Our Ref: A/175/11/

15th December 2011

Proposed two storey extensions & alterations
Orchard Cottage Rectory Lane Angmering

Block plan. Scale 1:500

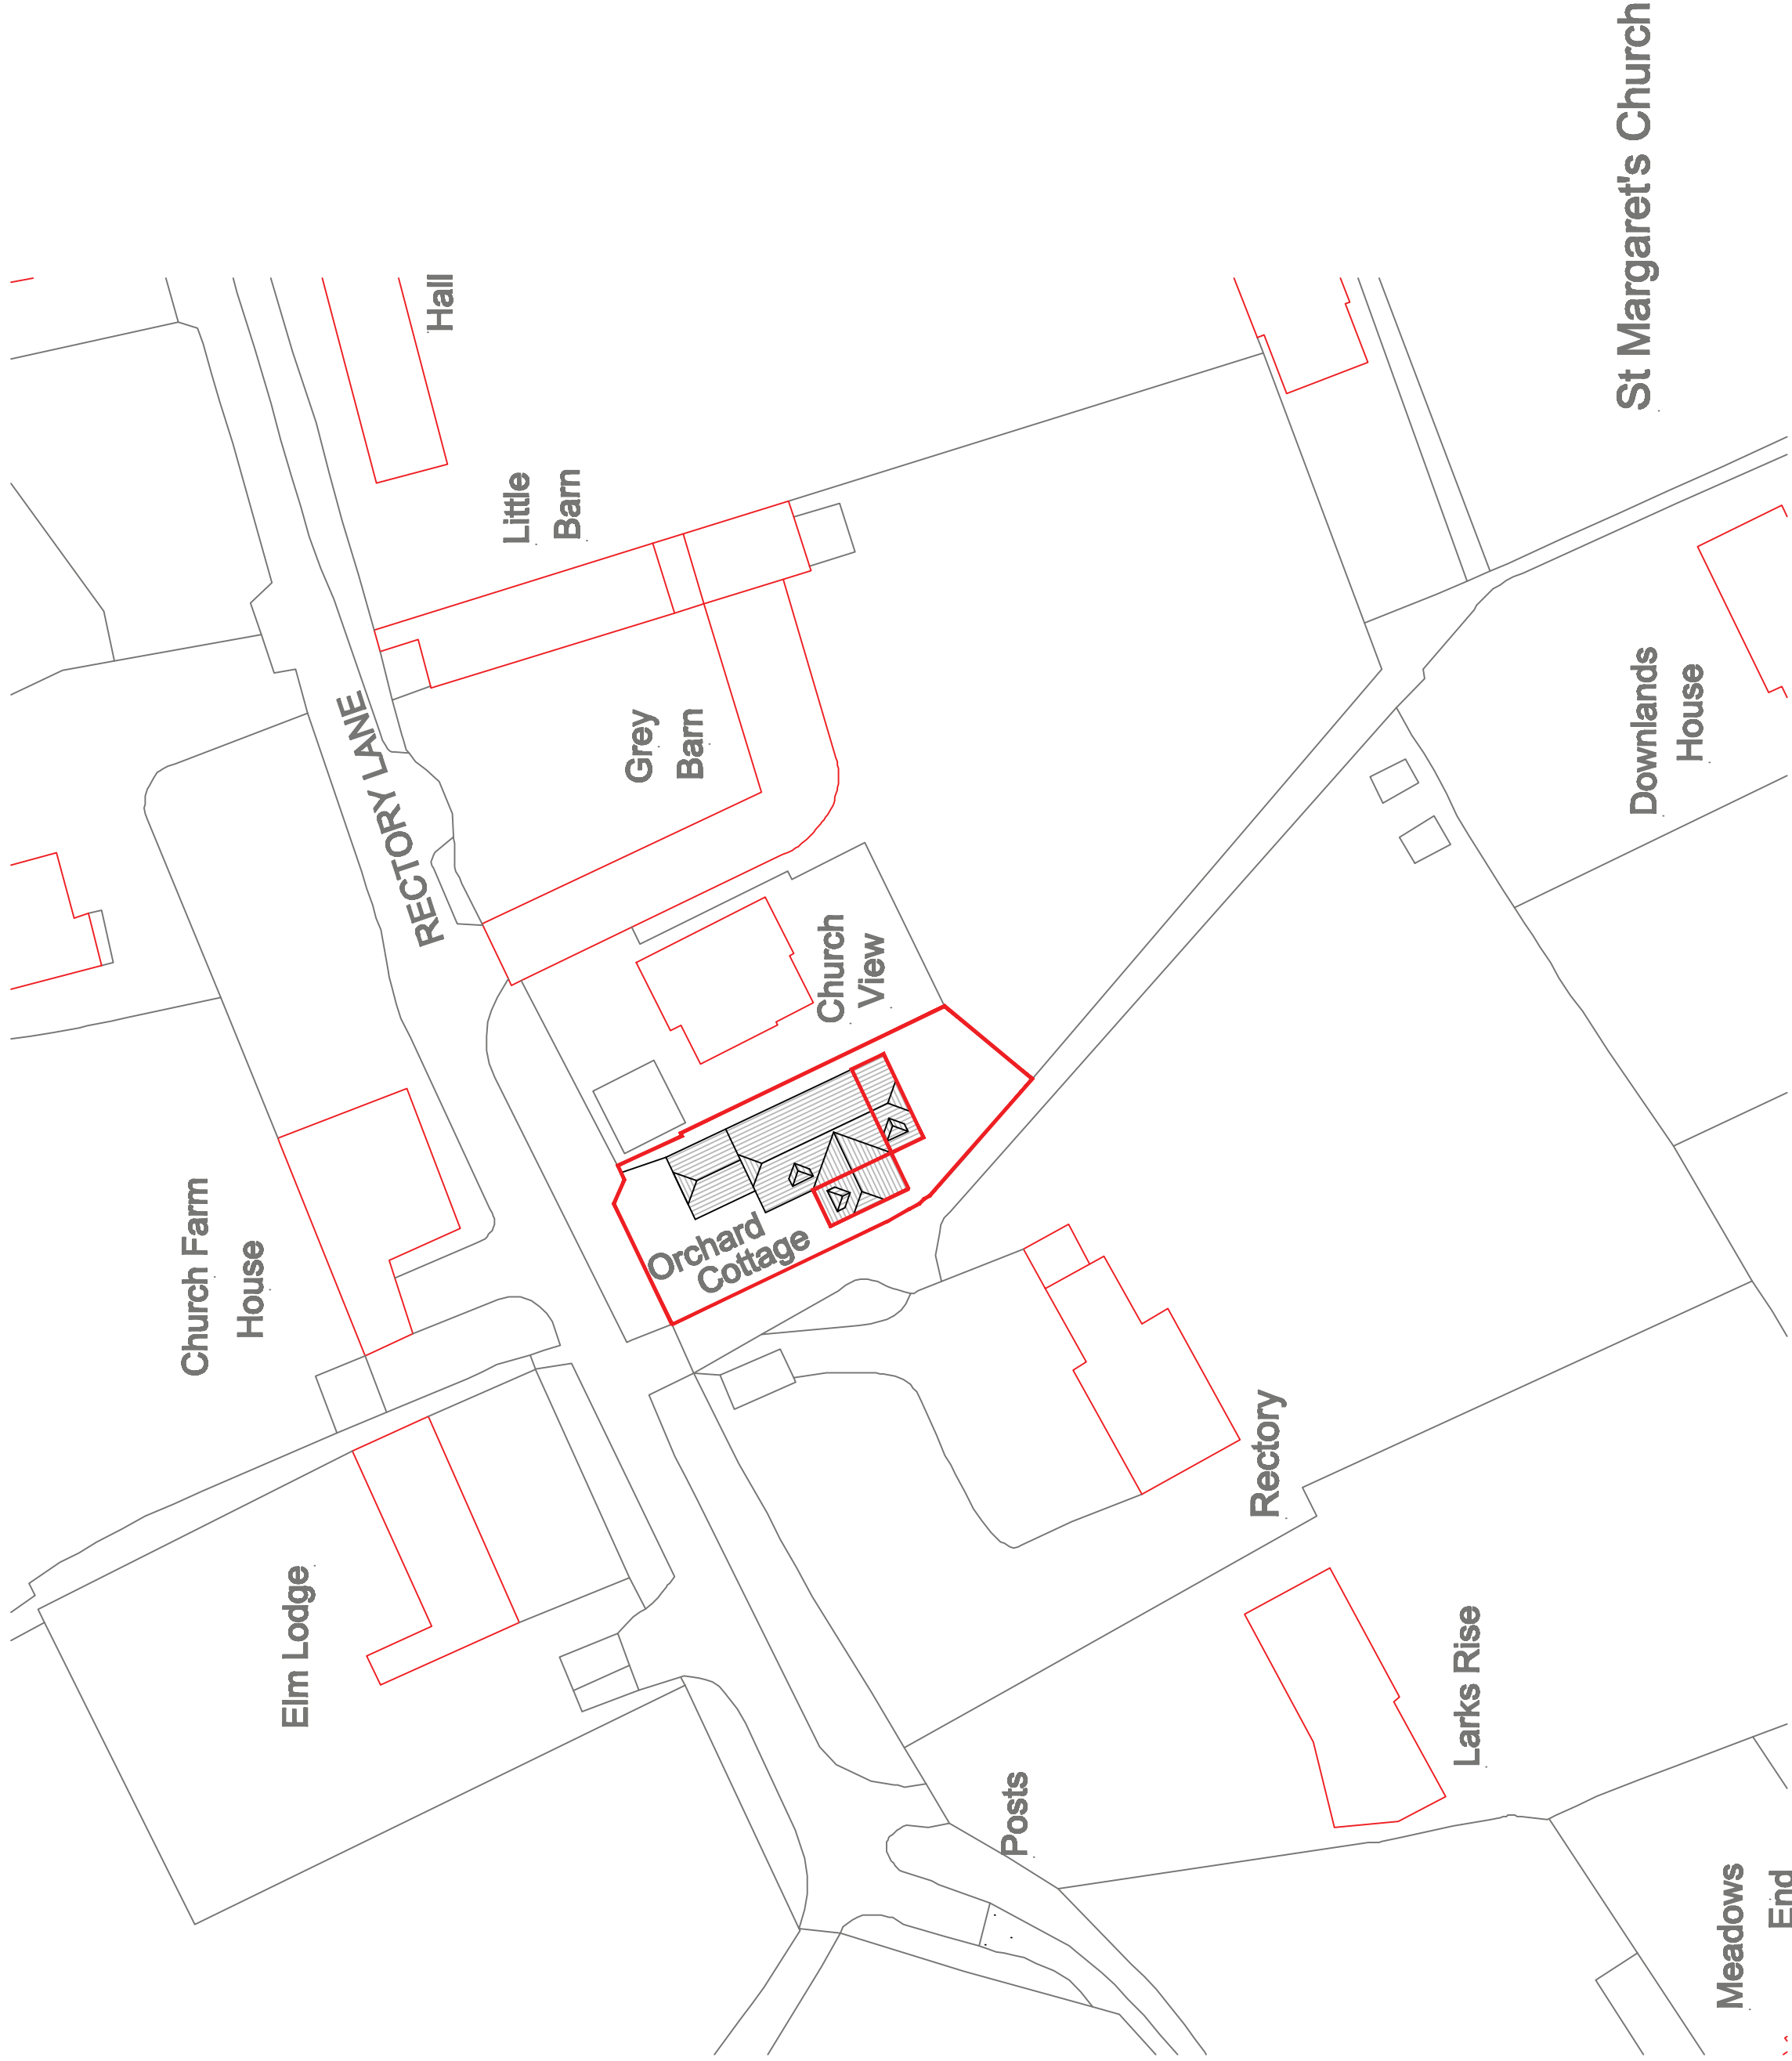
I require 1 electronic or 3 paper copies of a revised block/site plan showing a north point, in accordance with the guidance notes available on our website detailed below (click on National List).

I require 1 electronic or 3 paper copies of a revised location plan showing a north point, in accordance with the guidance notes available on our website detailed below (click on National List).
